**From:** Nicola Spencer on behalf of Planning  
**Sent:** 06 December 2017 11:47  
**To:** Planning Scanning; Planning.Responses  
**Subject:** FW: WA/75/17/PL Application - REF: OWPC16491  
**Attachments:** Land Registry Plan.pdf

From: David Grainger [REDACTED]  
Sent: 05 December 2017 17:08  
To: Planning  
Subject: WA/75/17/PL Application - REF: OWPC16491

Site Location Plan

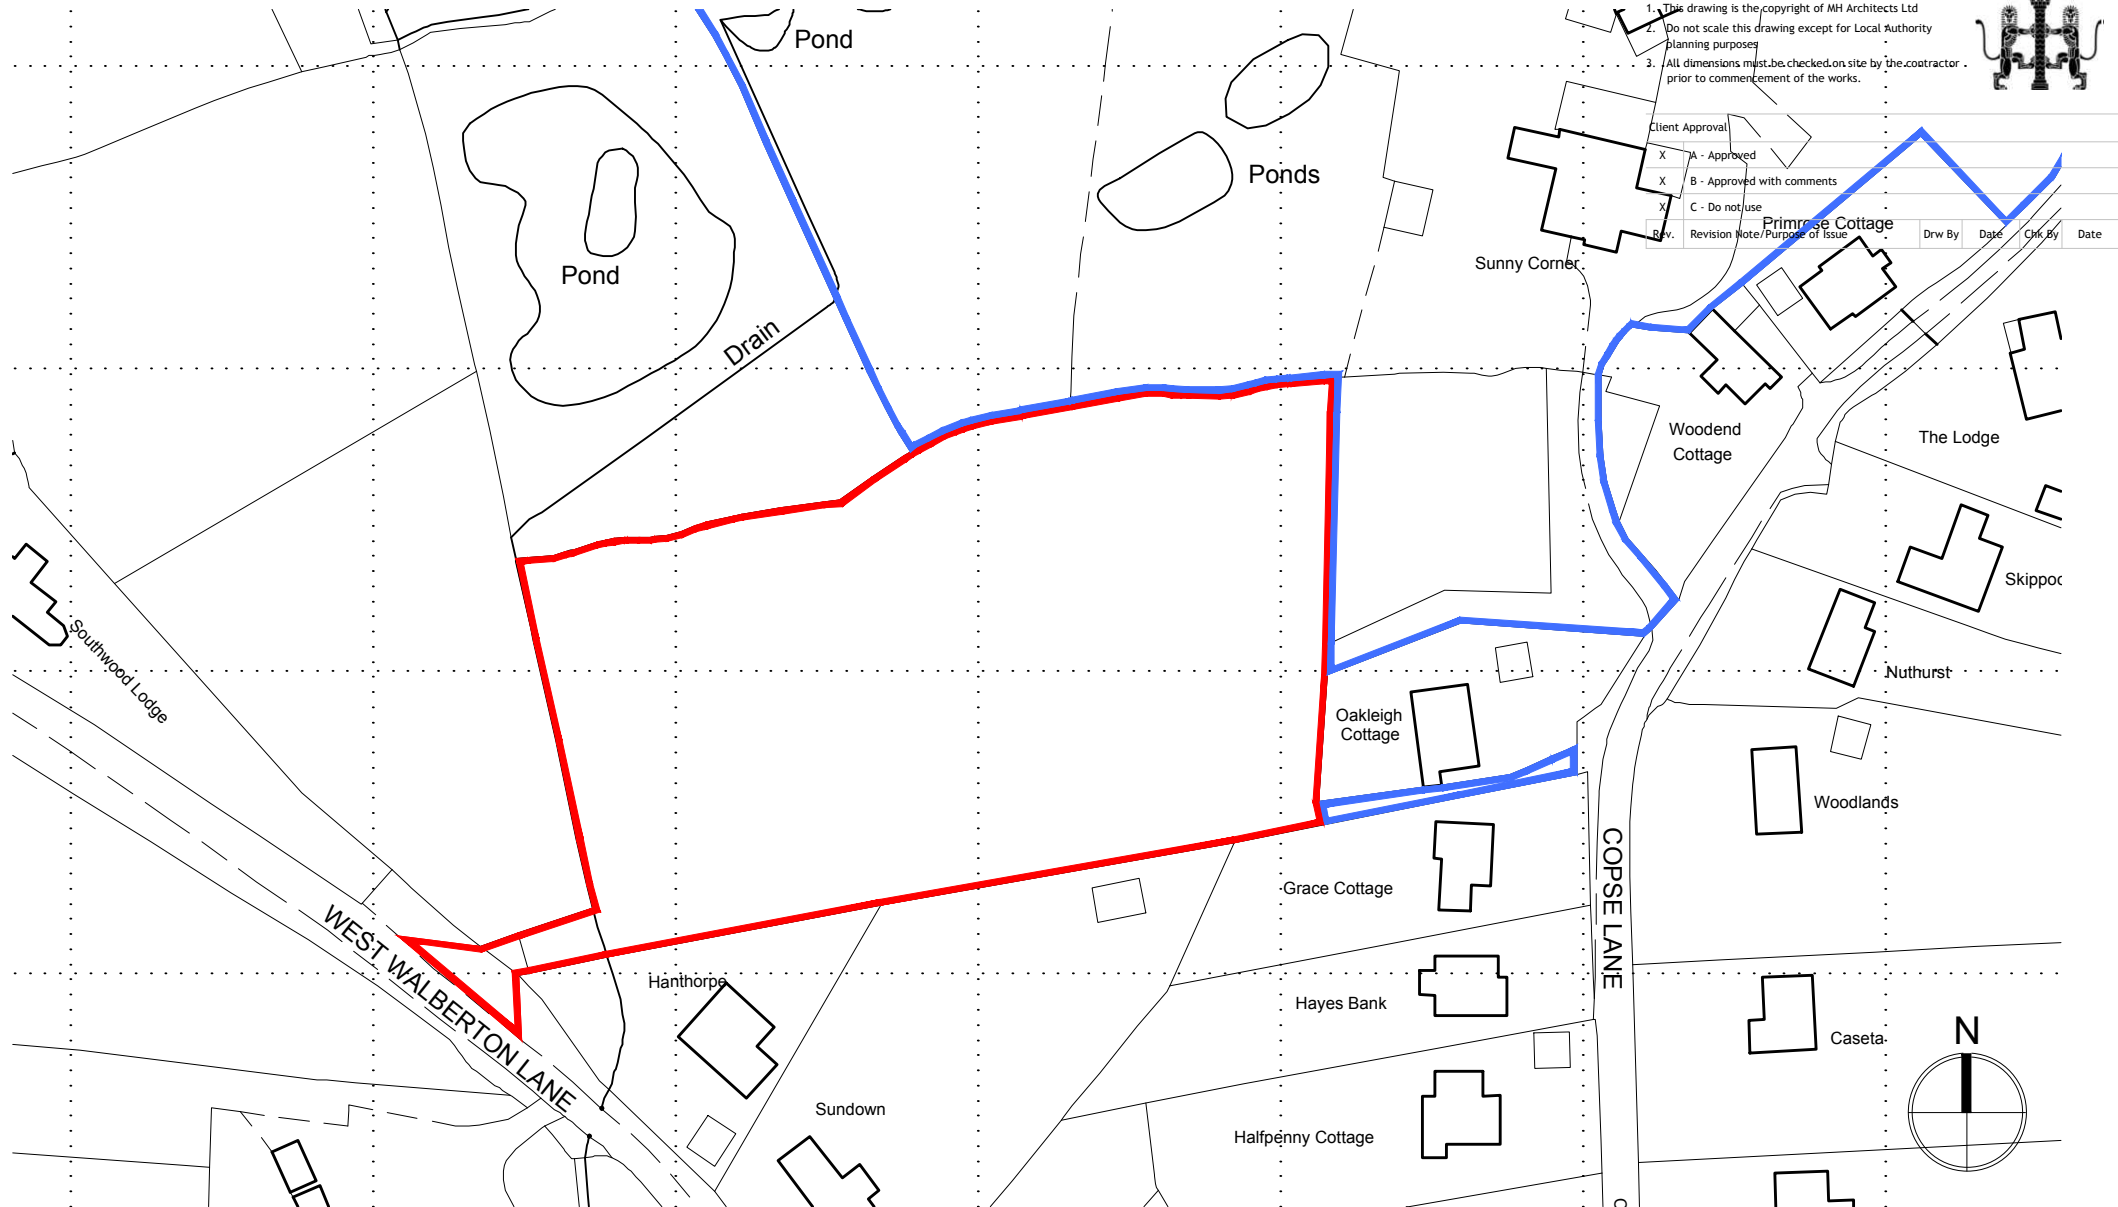
The local boundary plan that the applicants and their representatives are using is out of date.

The western boundary of Grace Cottage is actually positioned at least 40 meters further West than is indicated on the planning proposal.

Mr and Mrs Holden and their agents have been informed of this error but are still showing the incorrect boundary on their application.

Drawing title: Proposed Site Layout

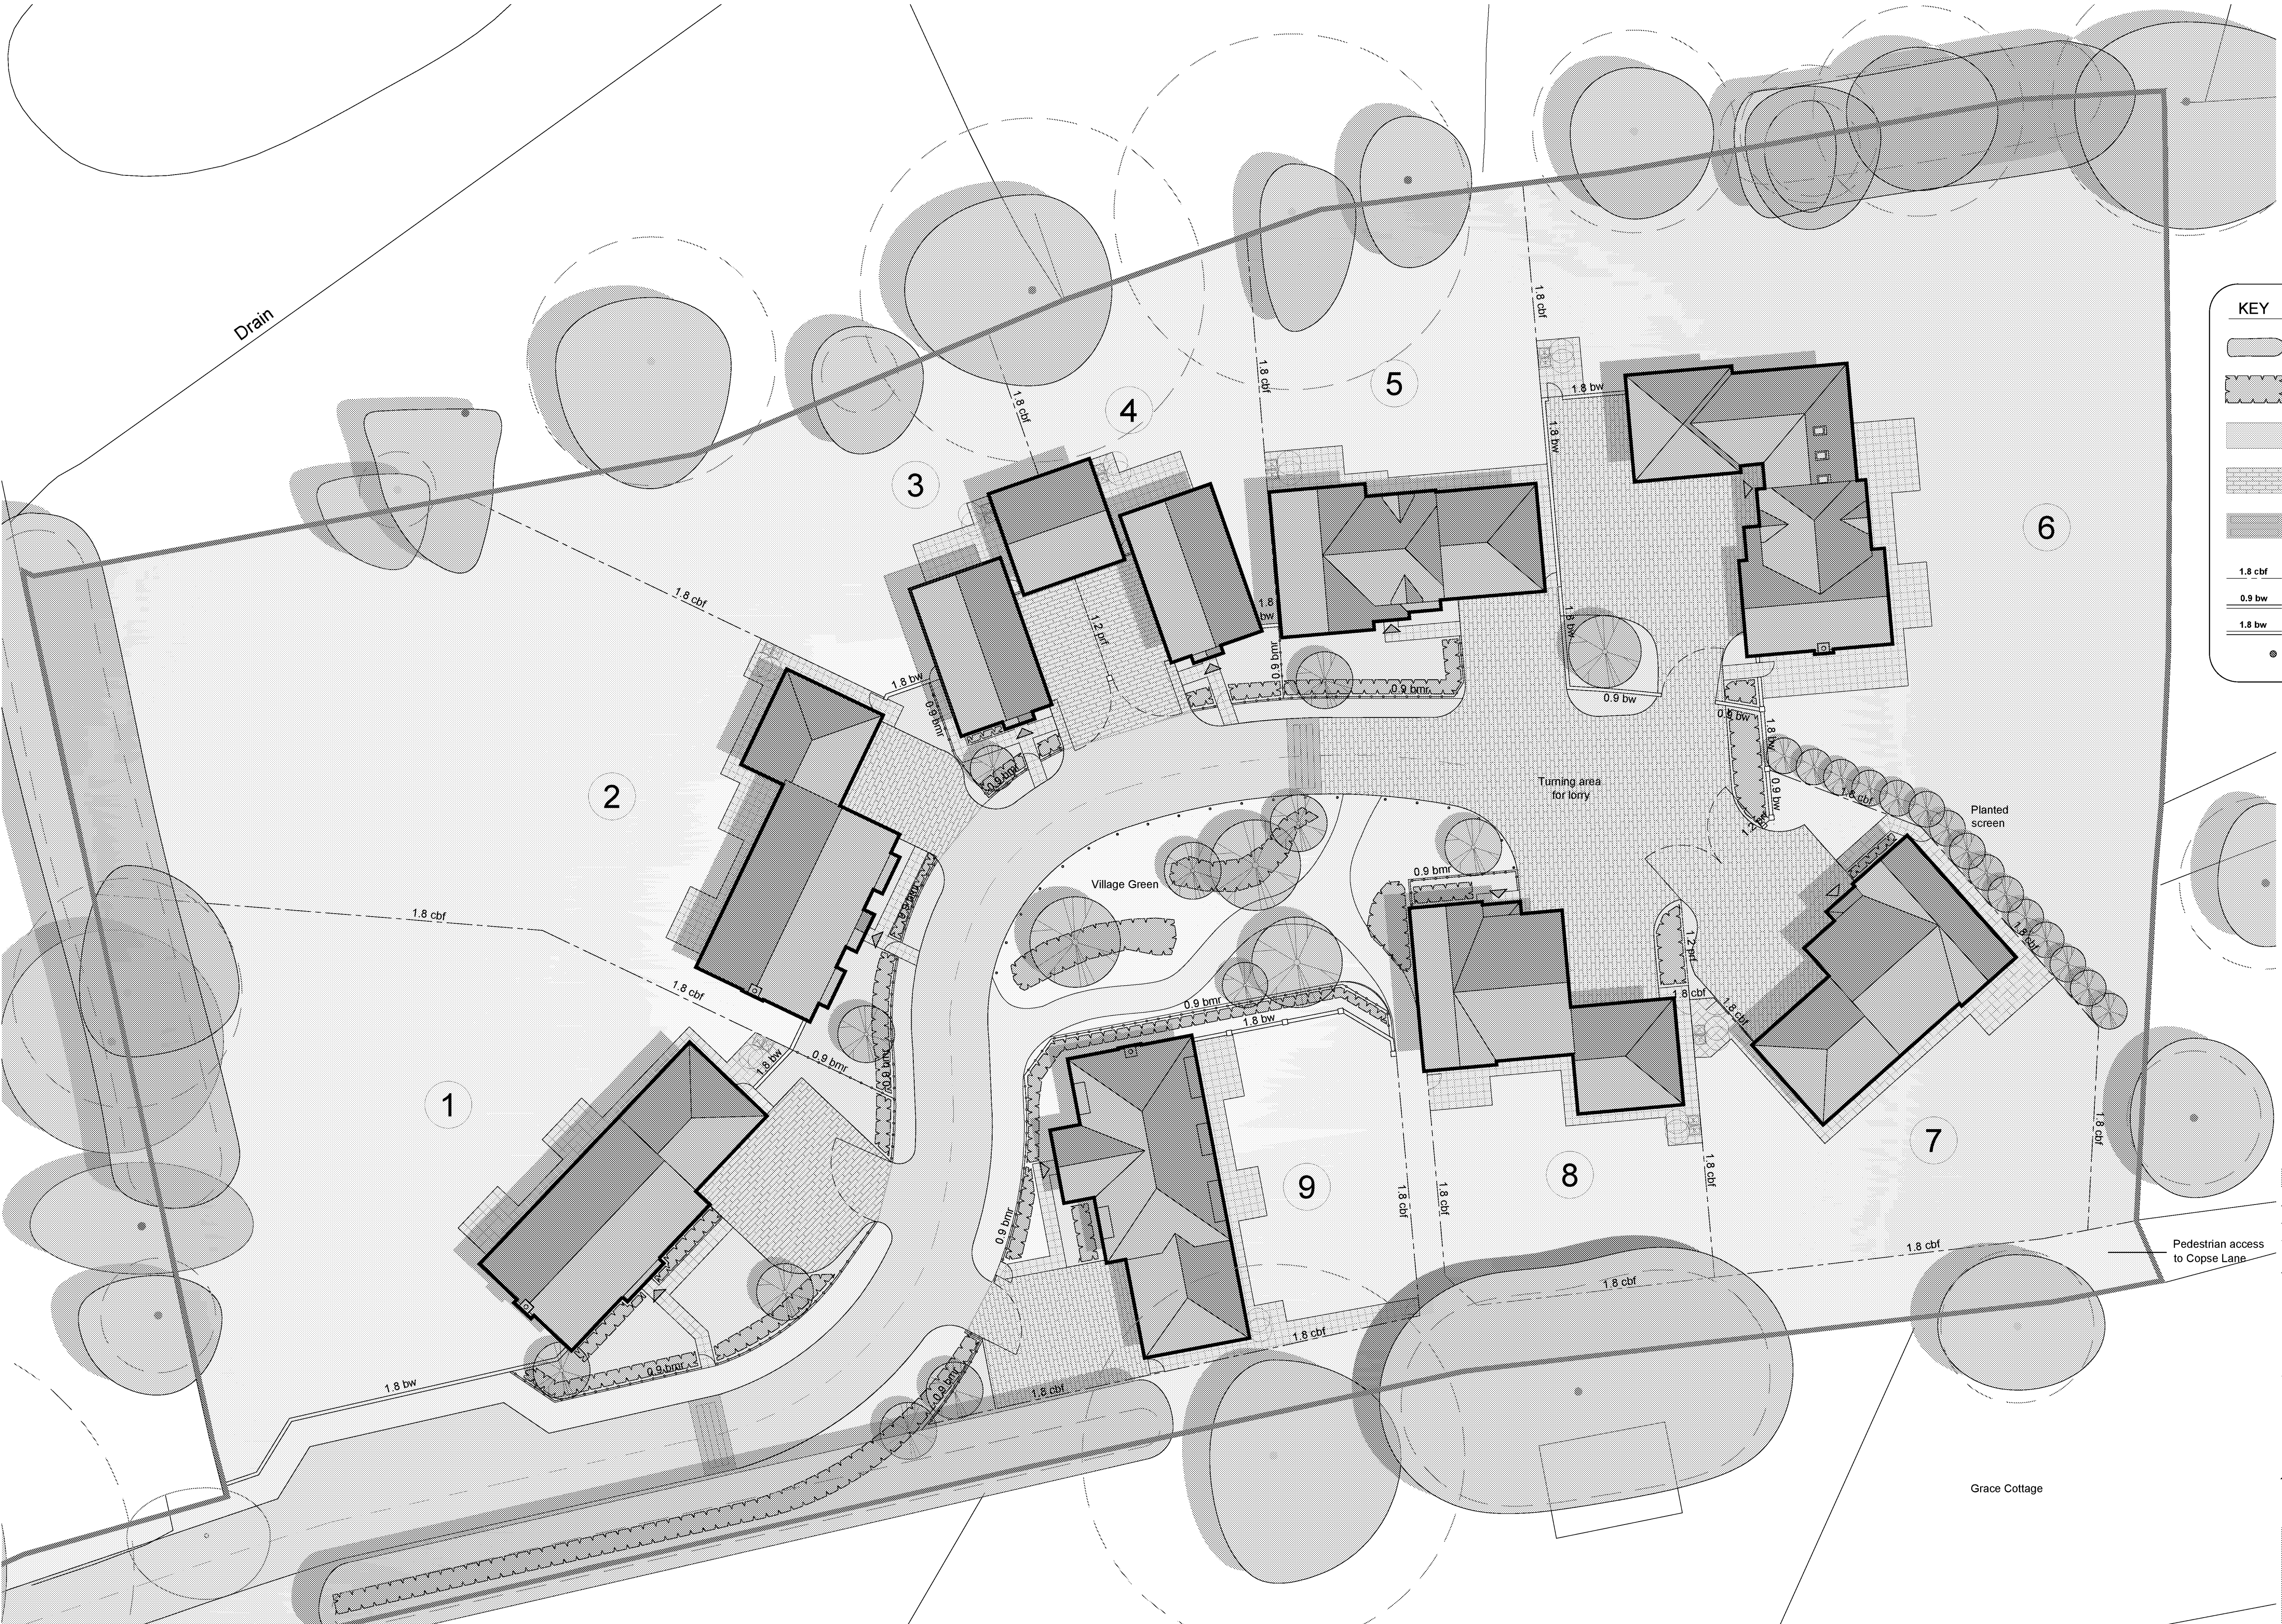
The whole of the Southern boundary of the proposed development, three double story houses, will be overlooking the garden of Grace Cottage.

As indicated by other objections, no mention has been made of the provision of privacy or sound control fencing between the proposed development and the adjacent properties. This would be a necessity if planning is granted and we would very much like to know the type and quality of such fencing before any work begins.

No mention has been made of subsequent ownership and maintenance of the new access points that are proposed. Vehicle access from West Walberton Lane and pedestrian access onto Copse Lane. It would be interesting to know who will be responsible for the upkeep of these potentially well used access points?

Copse Lane and the immediate vicinity do not have any communal lighting installed. I sincerely hope that this will be the case if this development is given permission. We have enviable dark skies in this locality and light pollution is something we would strenuously object to. As the proposed development has direct line of sight into the residential

rooms of Grace Cottage, any permanent lighting would be detrimental to living standards. It would also cause serious disruption to the two properties either side of the proposed pedestrian access path.
